Architect's Memo Architectural Narrative

RE: **Station 415**
415 Cumberland Avenue
Portland ME 04101

FOREST AVENUE ELEVATION  
 SCALE: 1/8" = 1'-0"

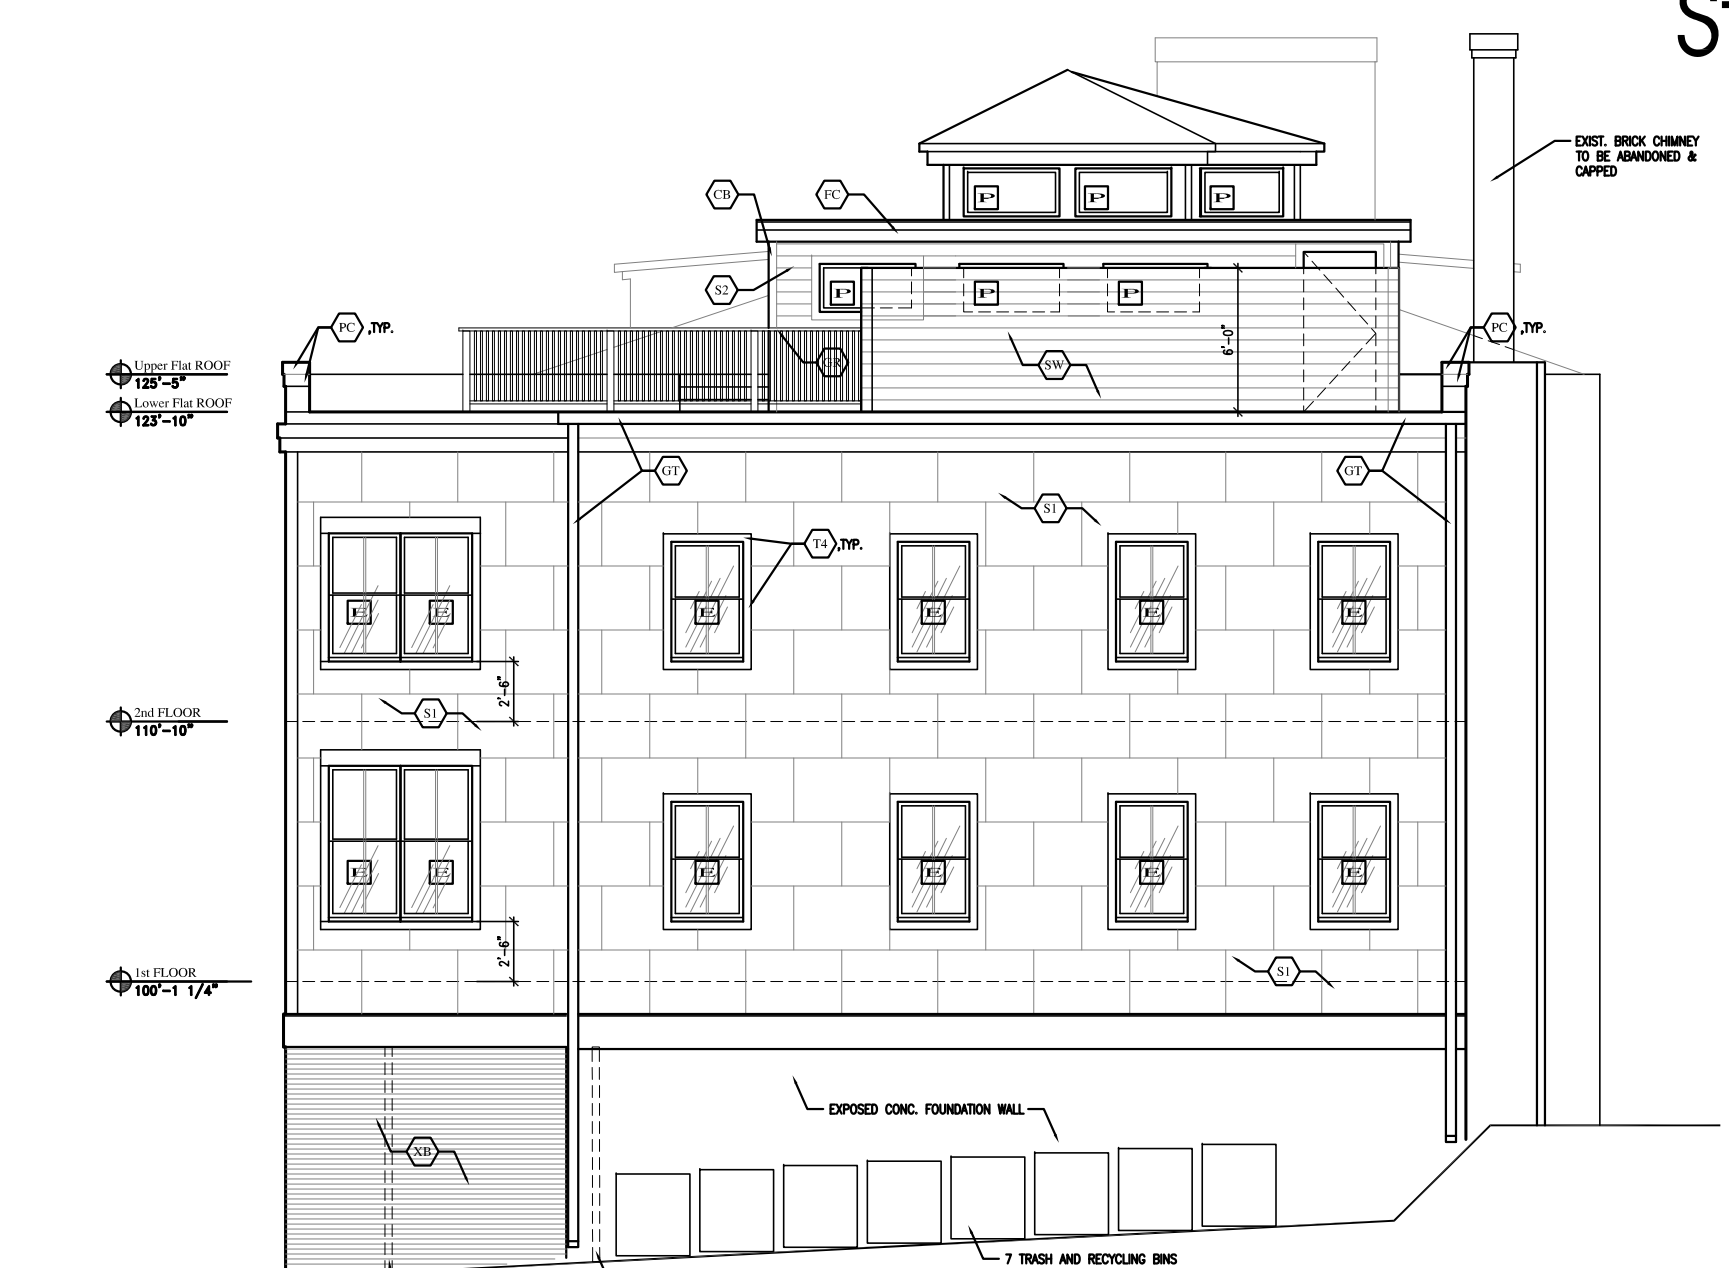
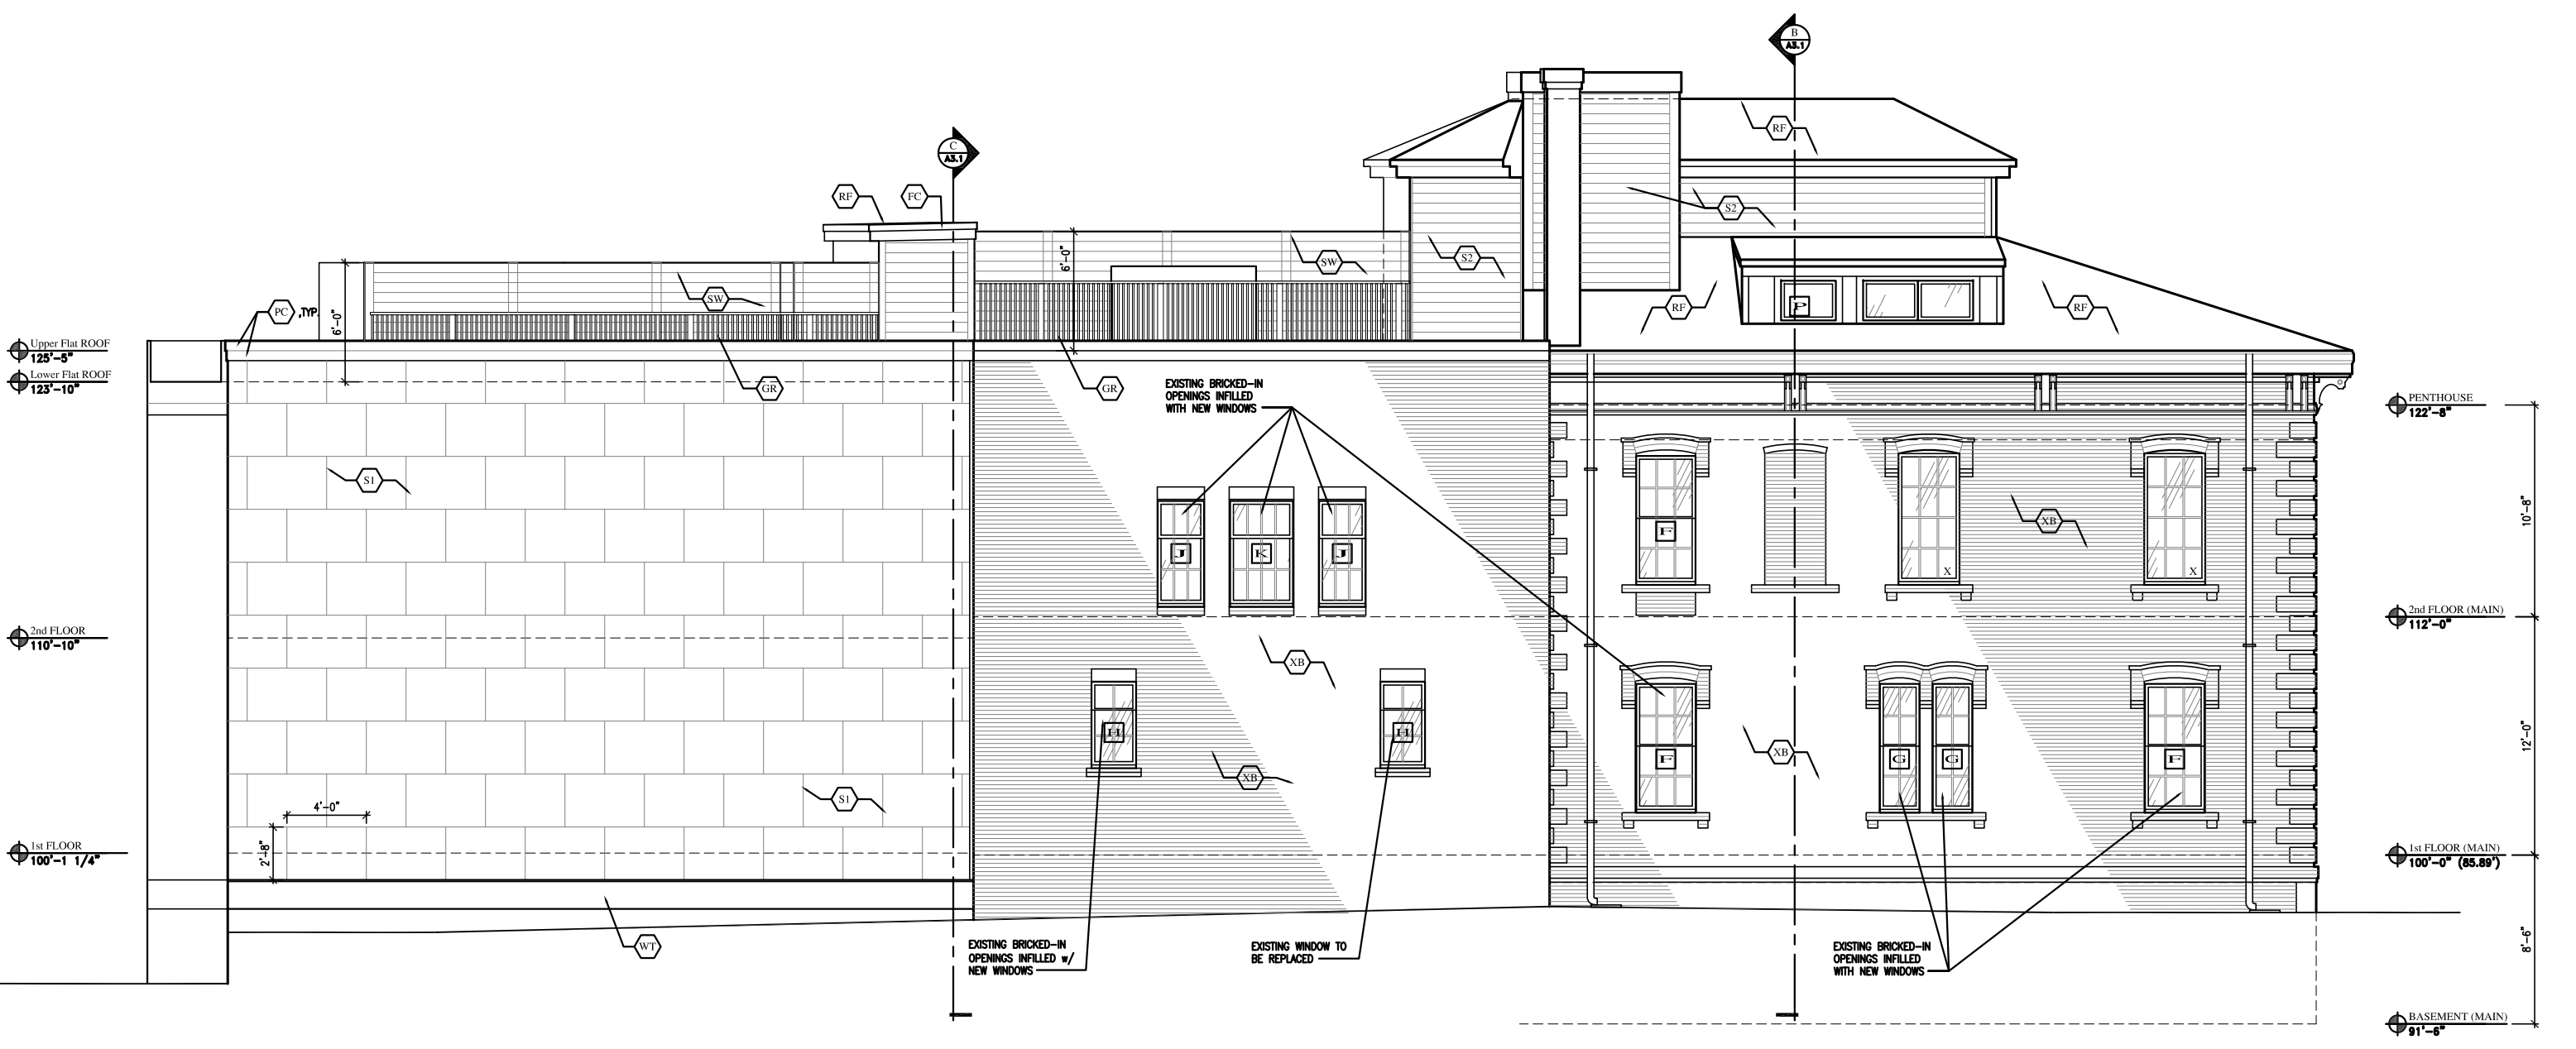
The existing brick façade will be repaired and cleaned as needed as noted in the drawings. The planning department has indicated a concern regarding the new cement panel system and its relation to the existing brick portion of the façade. The panels themselves will be applied in a rain-screen fashion to ½" furring strips to allow for the required drainage/weeping behind the panels. We

The new cladding color is yet to be determined. The Planning Board has recommended a color that is subdued and perhaps picks-up some of the color from the front portion of the building. We have shown a yellow/beige color in the first rendering and after review by HP and Planning staff has since been revised to show a muted grey option.

HP recommended that the cornice on the existing portions of the building should remain. Our first proposal removed the cornice from the back portion of the (at the cement panel area) façade. We have now included a continuous cornice that will be made out of a “built-up” system using the Hardie panel that will wrap around the rear of the building and terminate at the downspout on the alley-side elevation. (see revised elevation rendering)

intend to maintain the existing reveal that separates the brick from the wood horizontal siding that is created at the corner by making sure that the new panel siding sits back (4-5 inches) from the brick wall in a similar fashion to the current offset.
